DOC16/553132  
SSD 7709

**Moorebank Precinct West - Stage 2 SSD 7709**

### OEH comments on Moorebank Precinct West - Stage 2 SSD 7709

Figure 4-1: MPW Stage 2 Site Raising (Basins/Site filling) within the Georges River PMF Extents

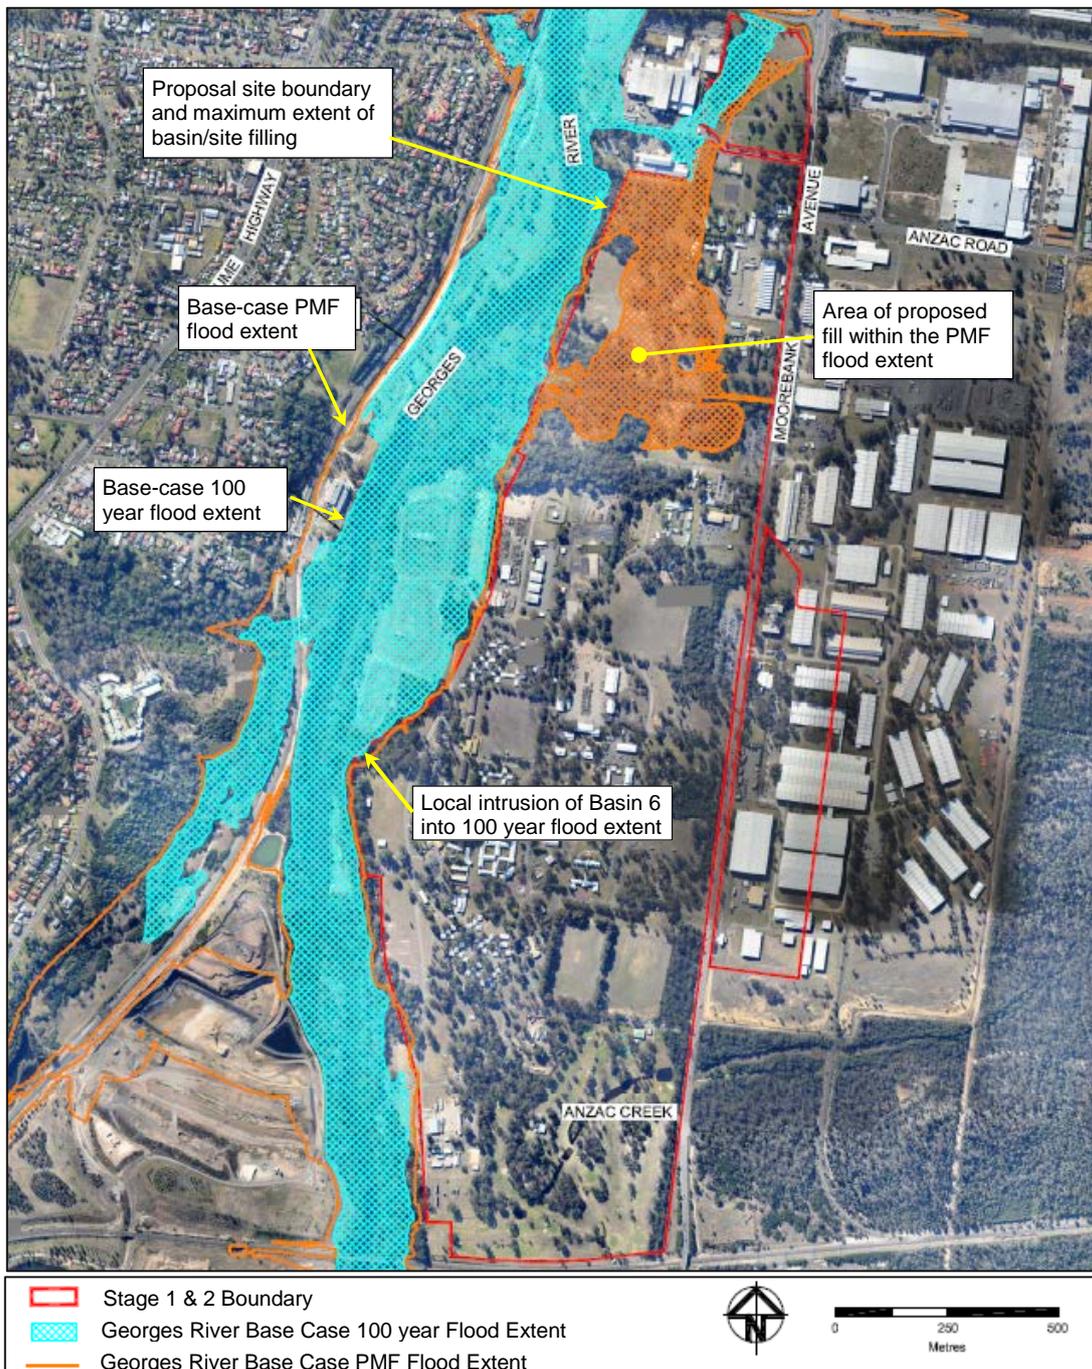
The majority of the proposed filling is outside the floodplain and figure 4.1 shows proposed filling at the northern one-third of the site which is situated above the 1% AEP but within the floodplain. The flood assessment methodology using HEC RAS hydraulic model is reasonable. Table 4.1 and figure 4.2 shows the extent of modelling and the report concludes that the flood impact from the filling and the proposal itself, for the full range of floods, is up to 0.01m. Table 4.1 also accounts for impacts upstream and downstream of the proposed site.
